AMENDMENT RECORD SHEET - POST DECISION

Application no: H06/0428/99

Description: Erect new dwelling with
detached garage

Location: Rectory Lane
Gedney Church End
Spalding
Lincs

WEST ELEVATION

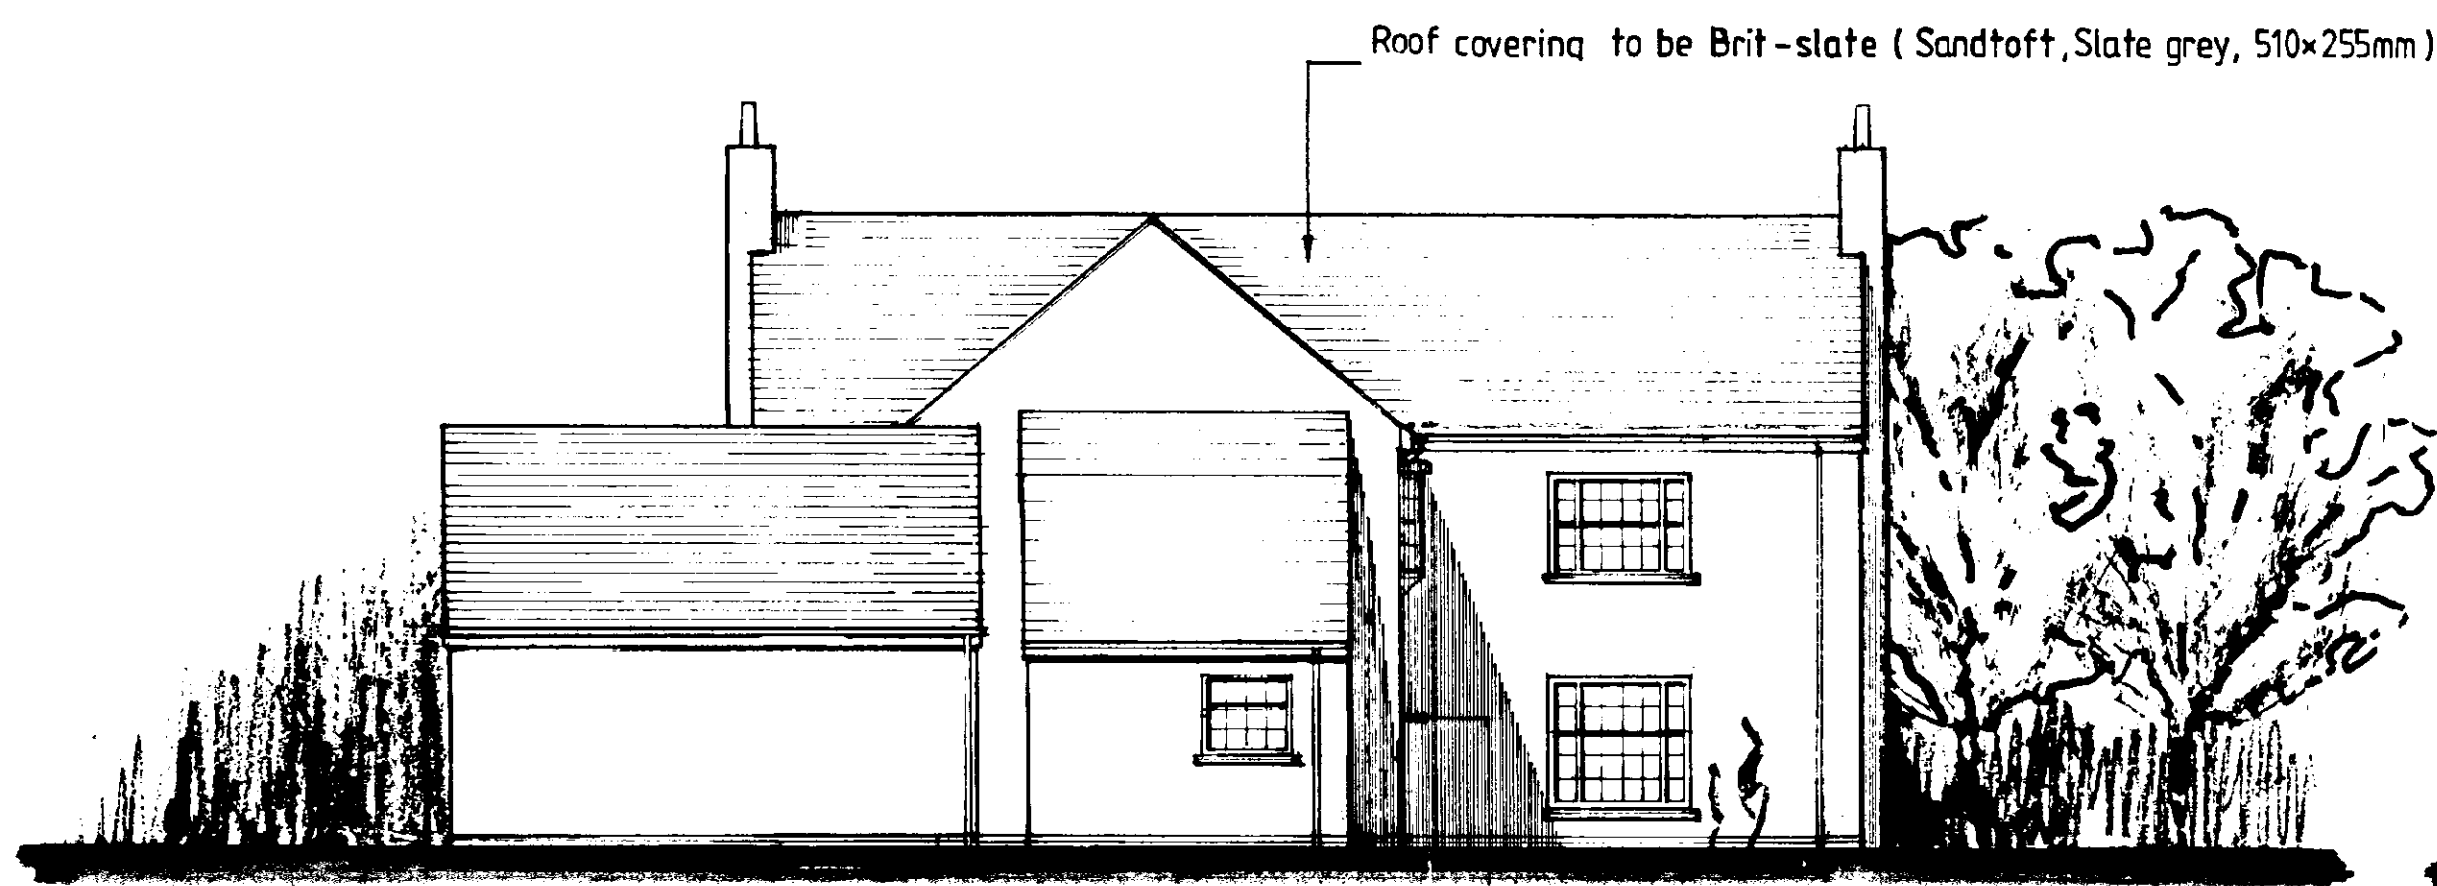
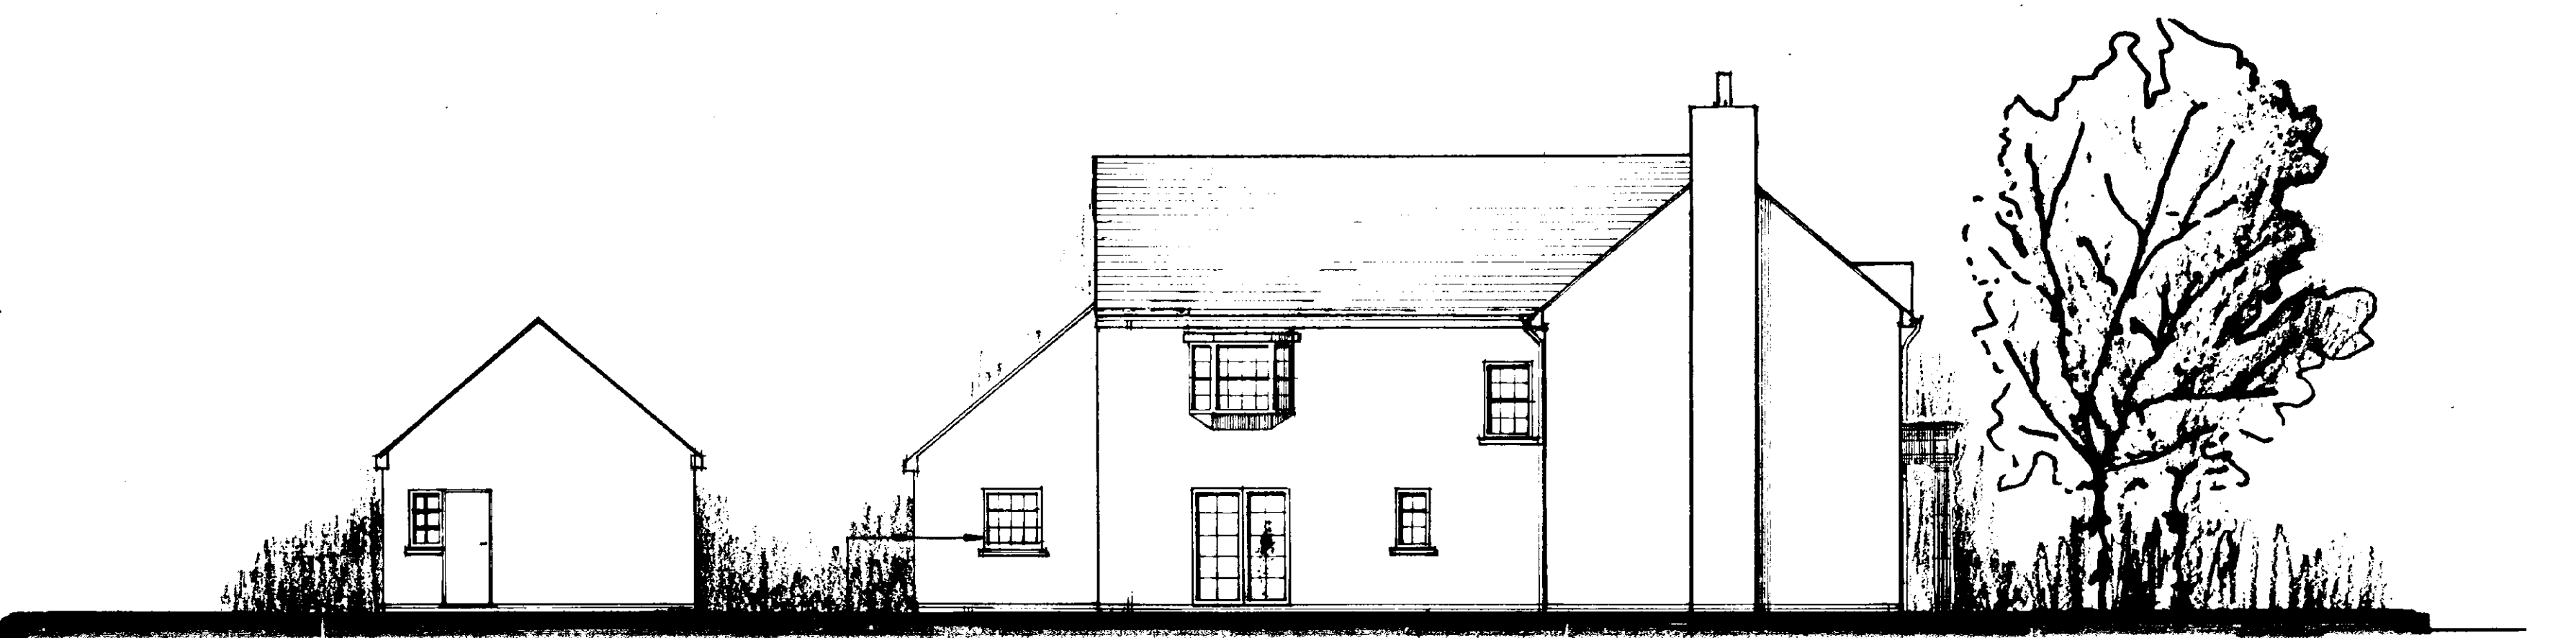
WINDOW AND DOOR SIZES REVISED
UTILITY EXTENDED
WINDOW ADDED IN UTILITY ON SOUTH ELEVATION
WIDTH OF REAR WING EXTENDED
STONE SUB SILLS ADDED
MINOR ADJUSTMENT TO SETTING OUT POSITION

Amendment: Minor alterations to exterior and siting
Dwg. No. AB/1, AB/9 and AK/2 Rev 3

scale	date	drawn
1:100	MARCH 99	MF
project no.	drawing no.	
1459	AK/2

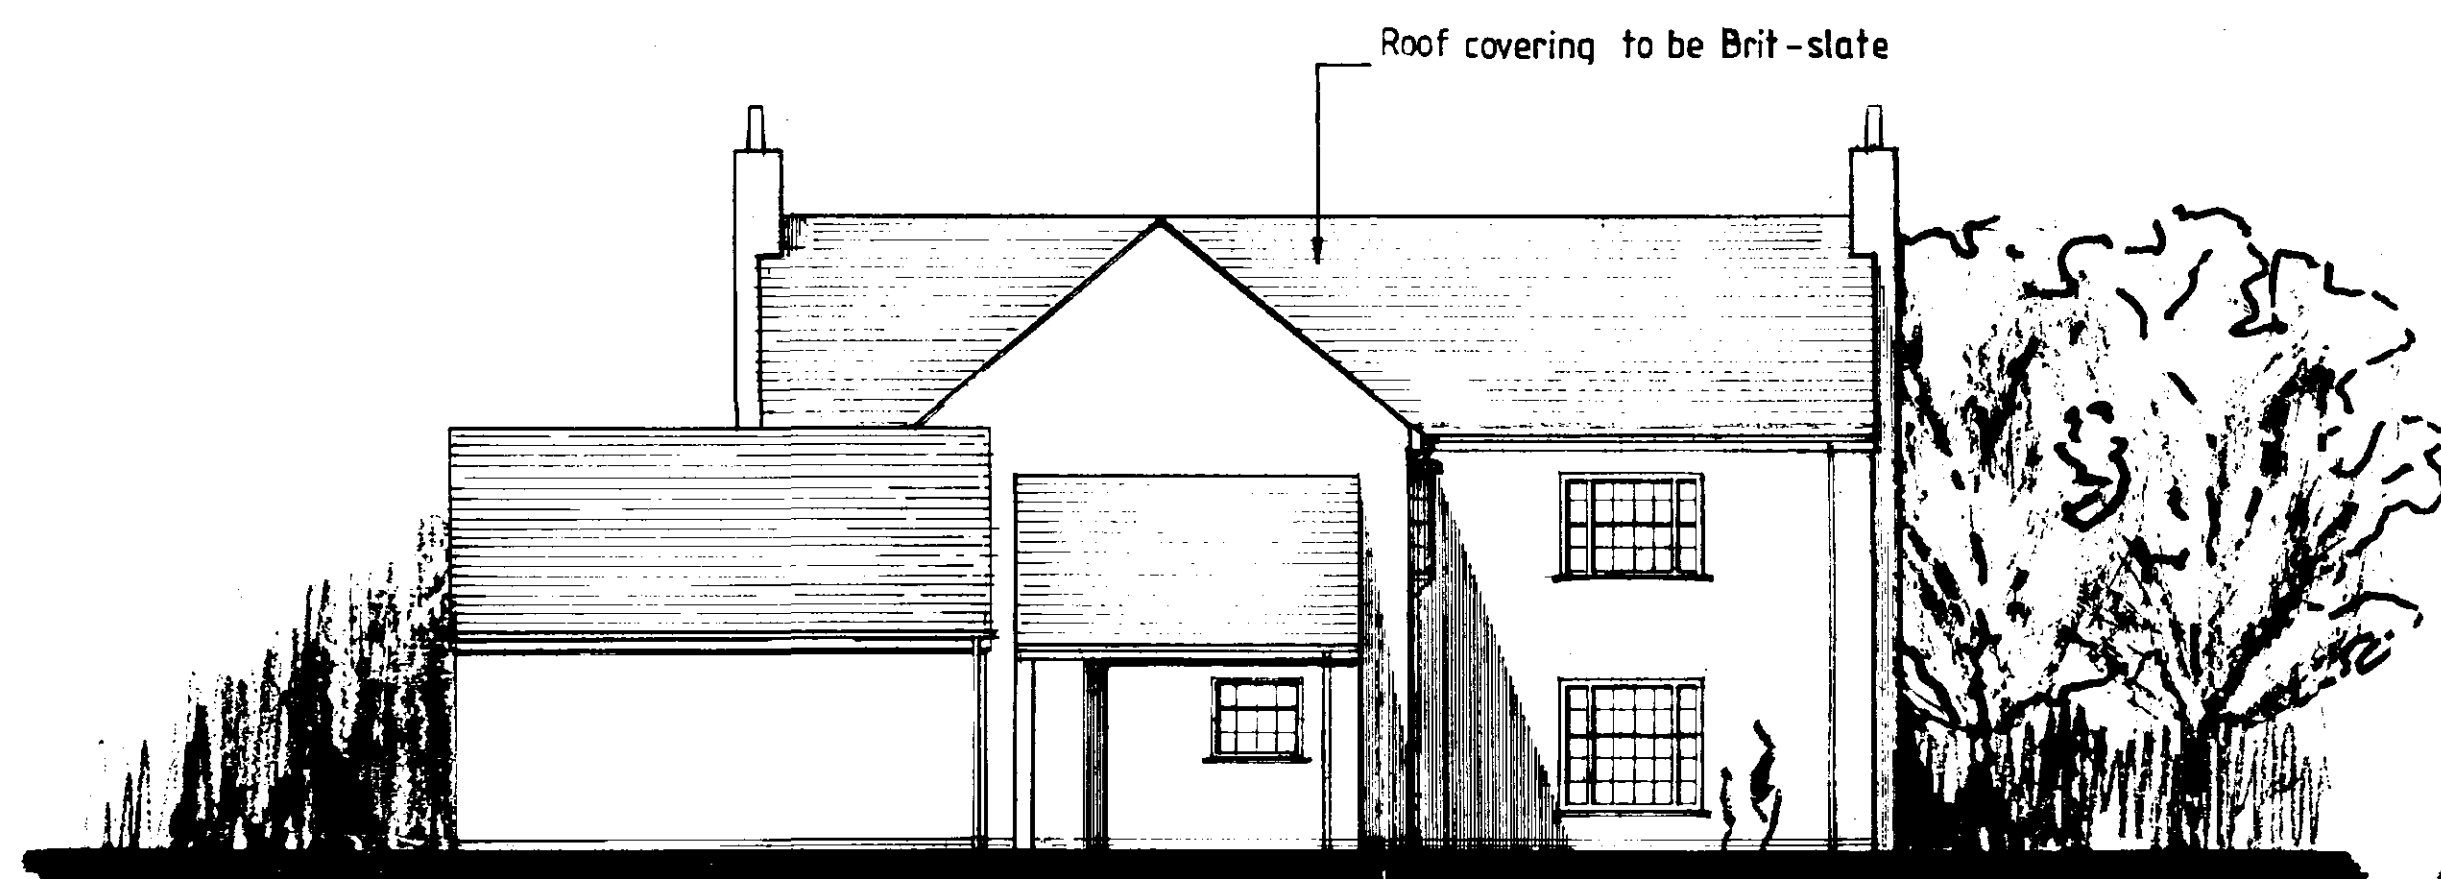
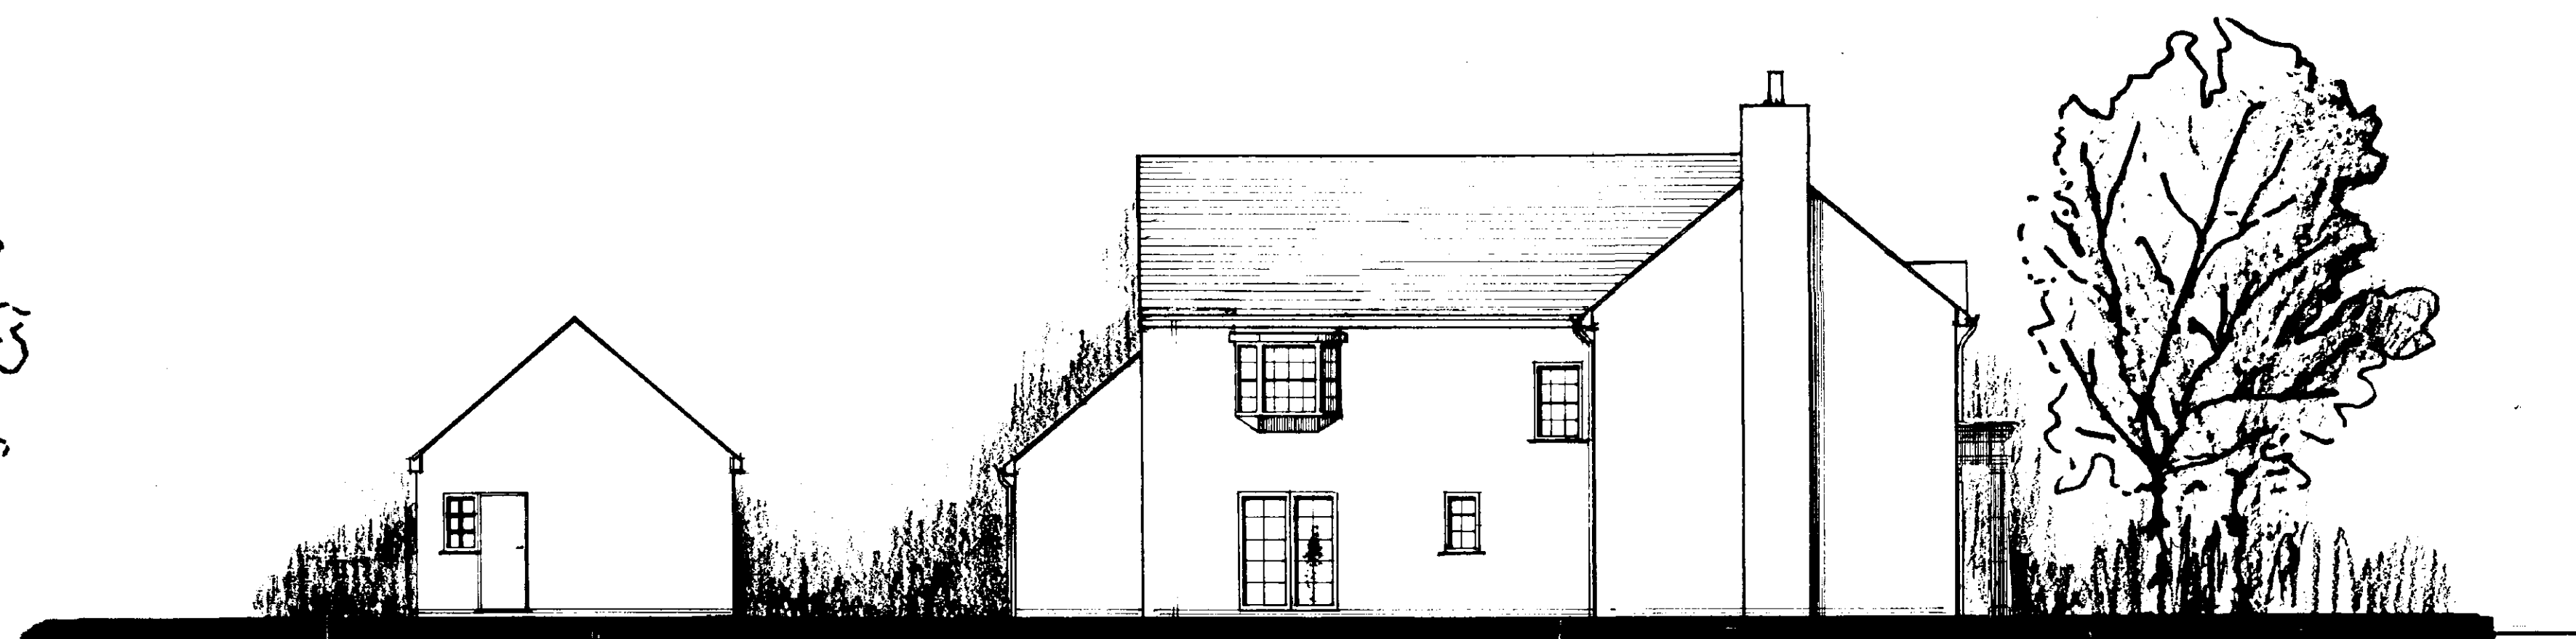
1. Garage roof repositioned to
have gable walls on North & South
elevations not east and west elevations

2. Quoins removed from corners of dwelling
3. Stone sub-sills removed from windows
4. Flat stone arches removed

Amendment: Reposition garage and minor external changes to house
Drawing No. AK/2 Rev 2
